Your ref 3/2012/0157P
Our ref OCE/EVP/ER/3/22/8453/LK
Date 6 July 2012

APPLICATION NUMBER 3/2012/0157P
LAND ADJACENT TO HOTHERSALL LANE, HOTHERSALL, PRESTON,
PR3 2XB
GRID REFERENCE 362101 436772

A planning application has been submitted by Mrs Julia Pye on behalf of Mr Tony Kieran for the erection of a multi-purpose agricultural building for the accommodation of his livestock and the storage of hay, straw and general agricultural items. A site inspection was undertaken on 28 June 2012, whilst the applicant, his agent and his cousin, who is also his landlord were present. The information provided at the meeting together with the written submissions, forms the basis of this appraisal.

Proposed South Elevation

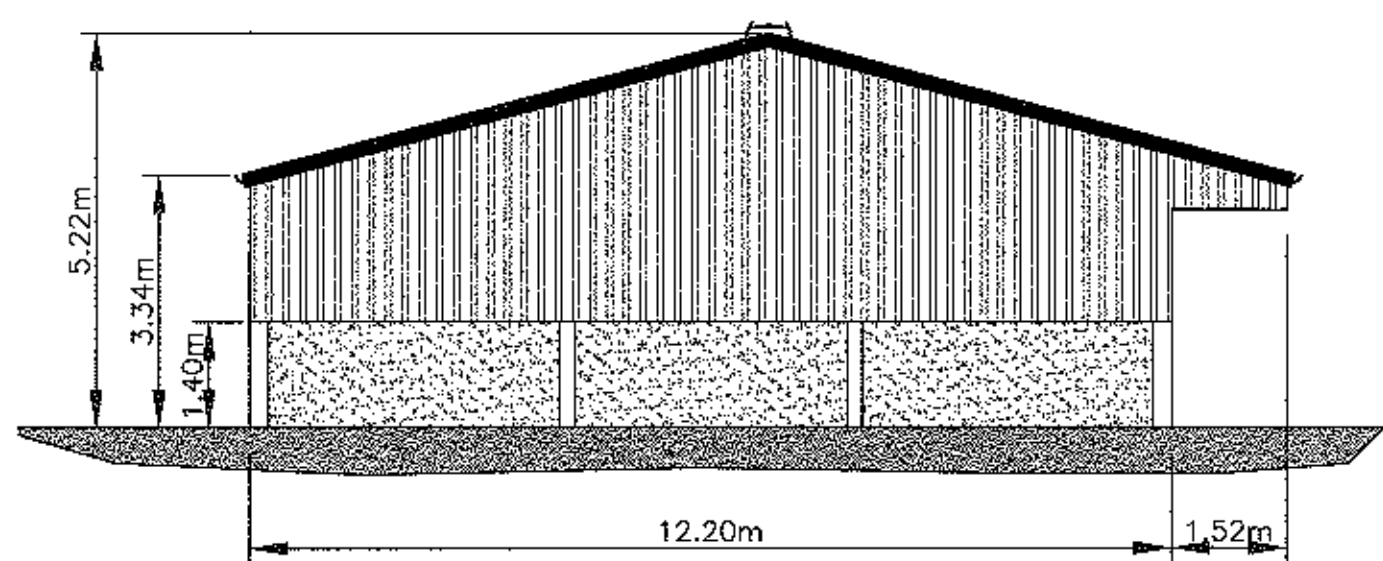
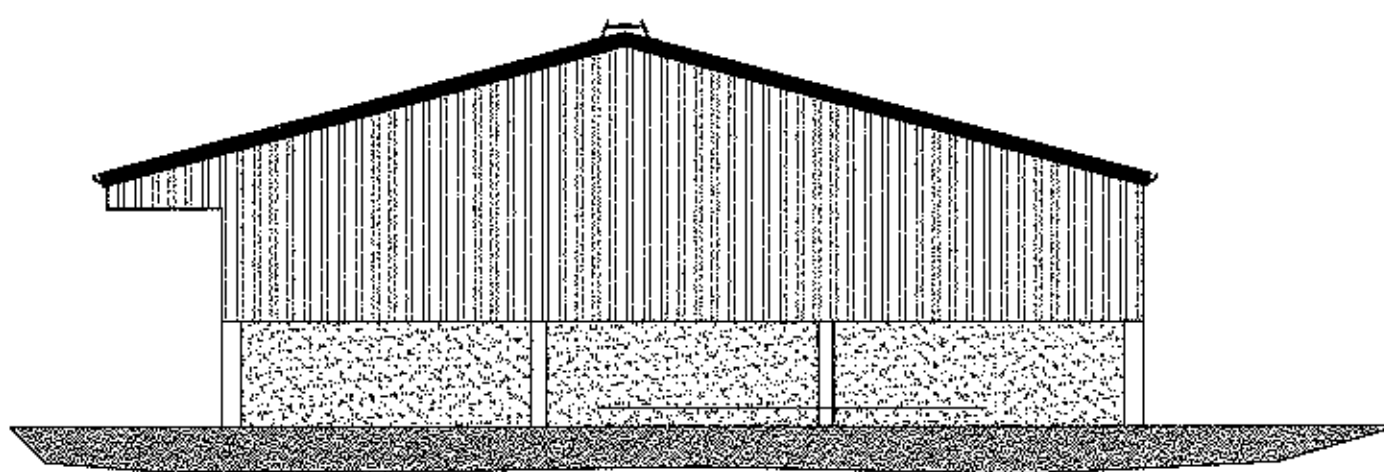
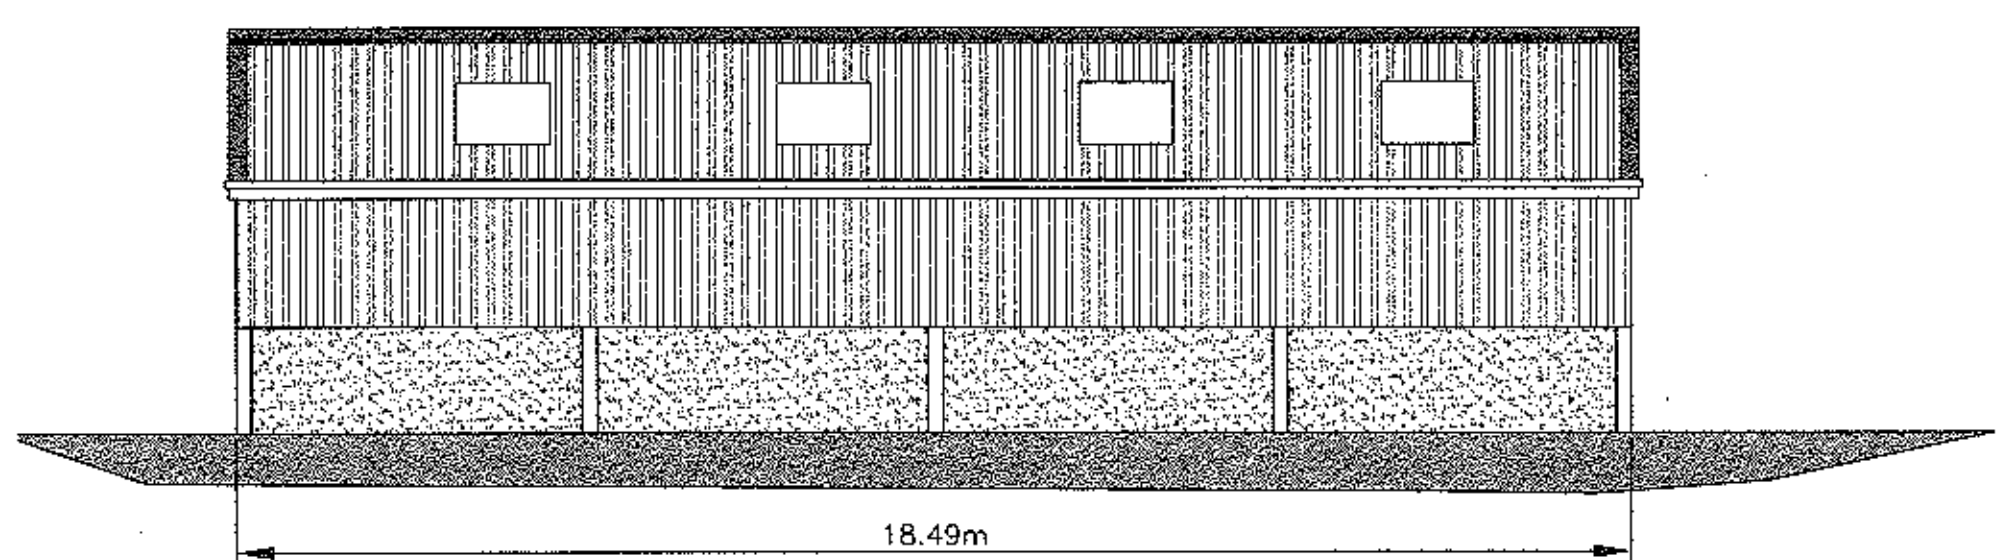
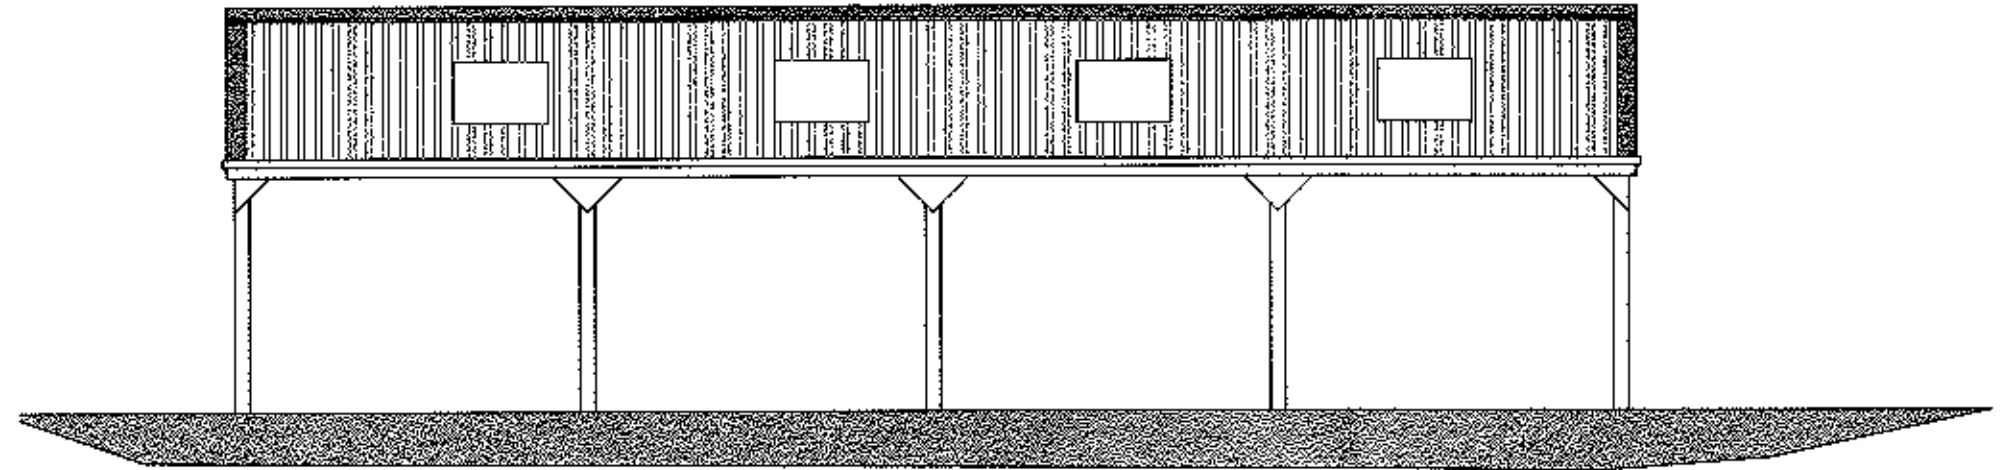
The design of the building is in accordance with the intended agricultural use and is a purpose built building. The materials proposed to be used are typical for this type of agricultural building and are in my opinion acceptable.

The open fronted elevation would allow for easy access to and from the building whilst providing good ventilation to livestock and forage kept within.

In my opinion, whilst the size of the proposed structure is slightly larger than necessary in terms of the current operations undertaken, I do not consider the size to be unacceptable and believe that it is in proportionate when considering the acreage available to the applicant and the proposed expansion of the flock.

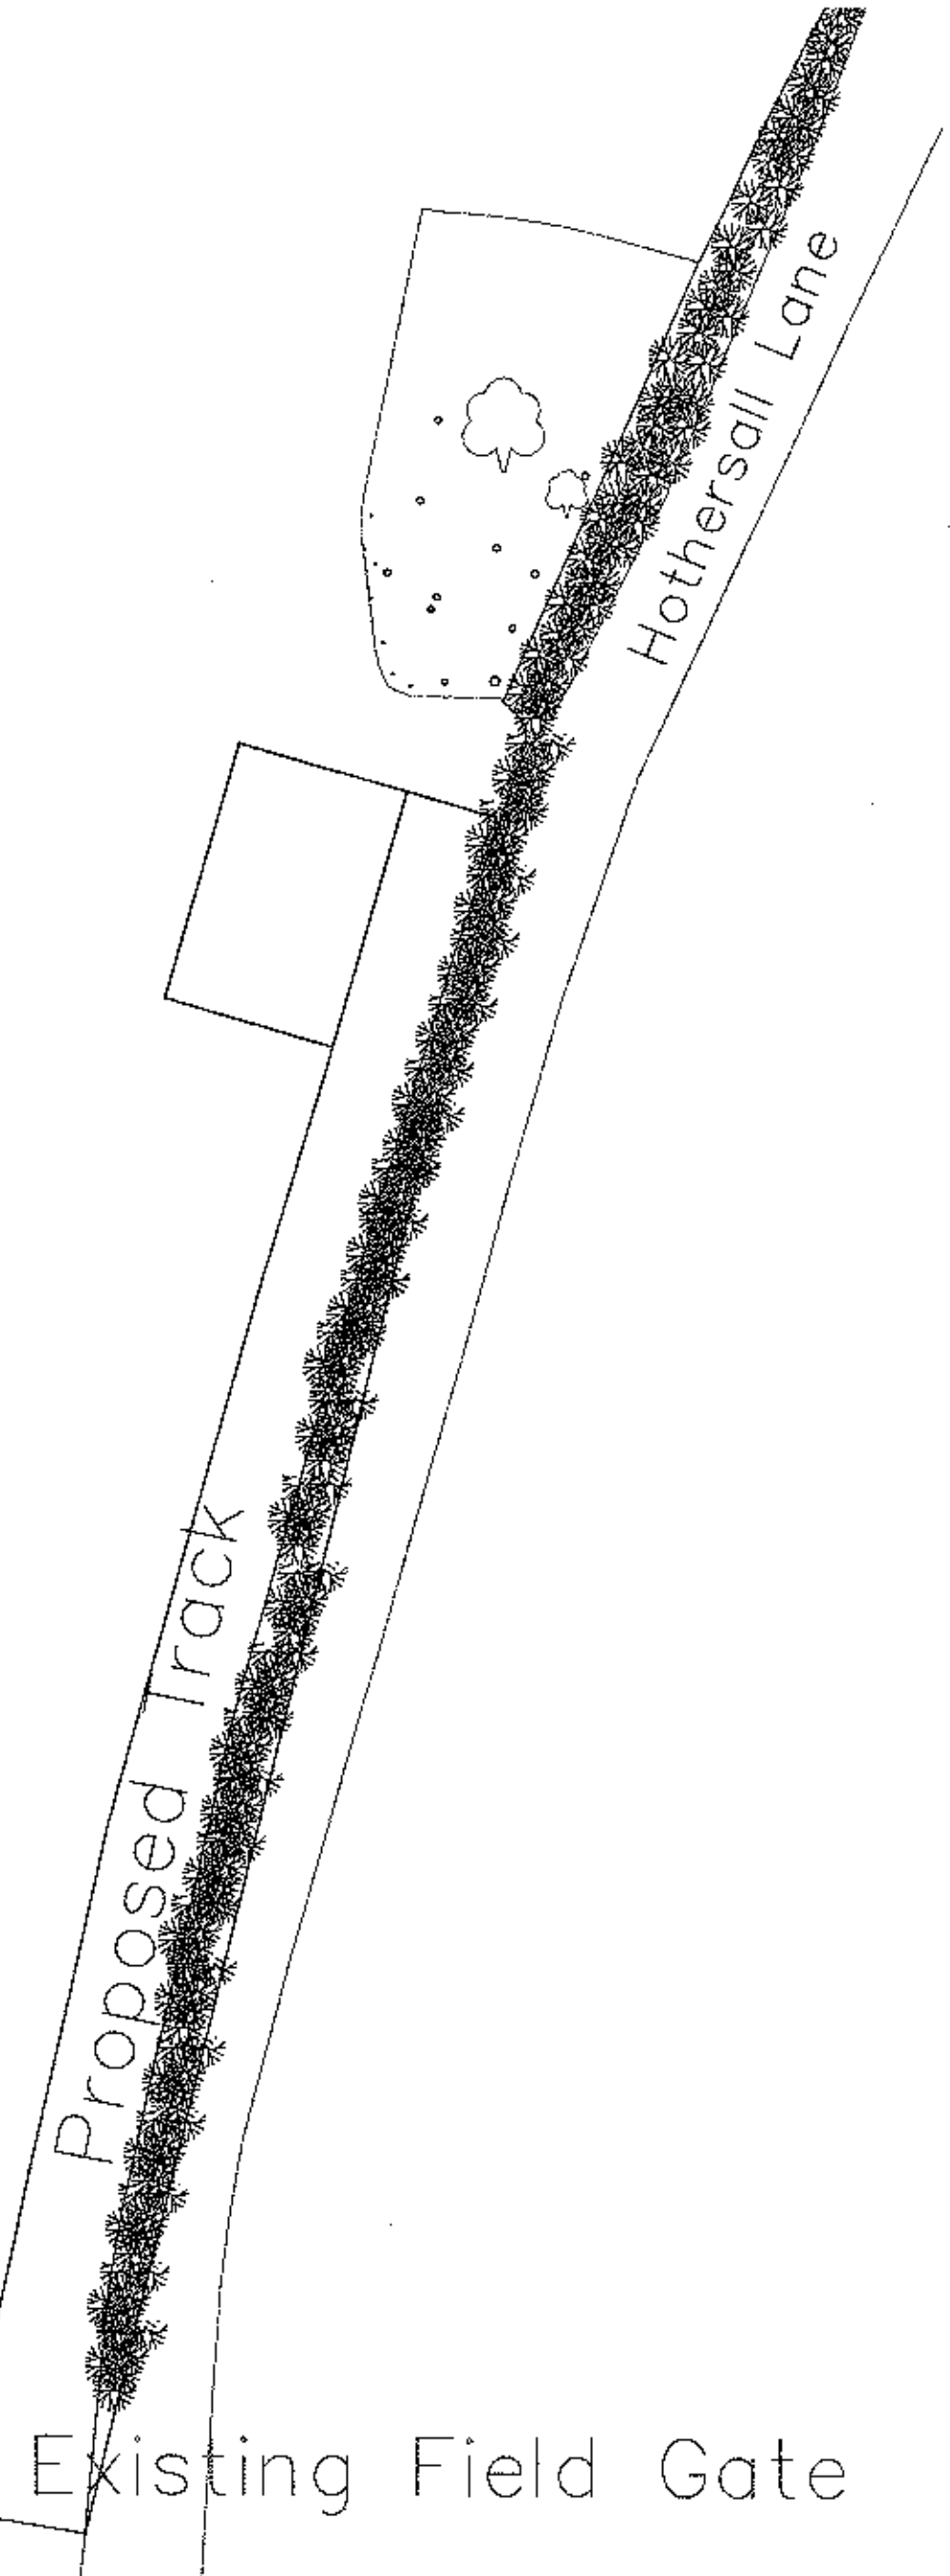
Whilst the proposed site of the building is not unacceptable and the position benefits from the presence of the adjacent woodland, in regards to the screening and shelter, the proposed position would require a track in excess of 100m to be created to serve it and there are no operational reasons for the proposed site. In my opinion, there are other positions within the field, including positions nearer to the existing field access, where the proposed development could be sited and which the Council may consider to be more appropriate.

Taking the above into account, I consider the siting of any development should be determined by wider planning policy matters, eg. the visual impact, as opposed to operational aspects.
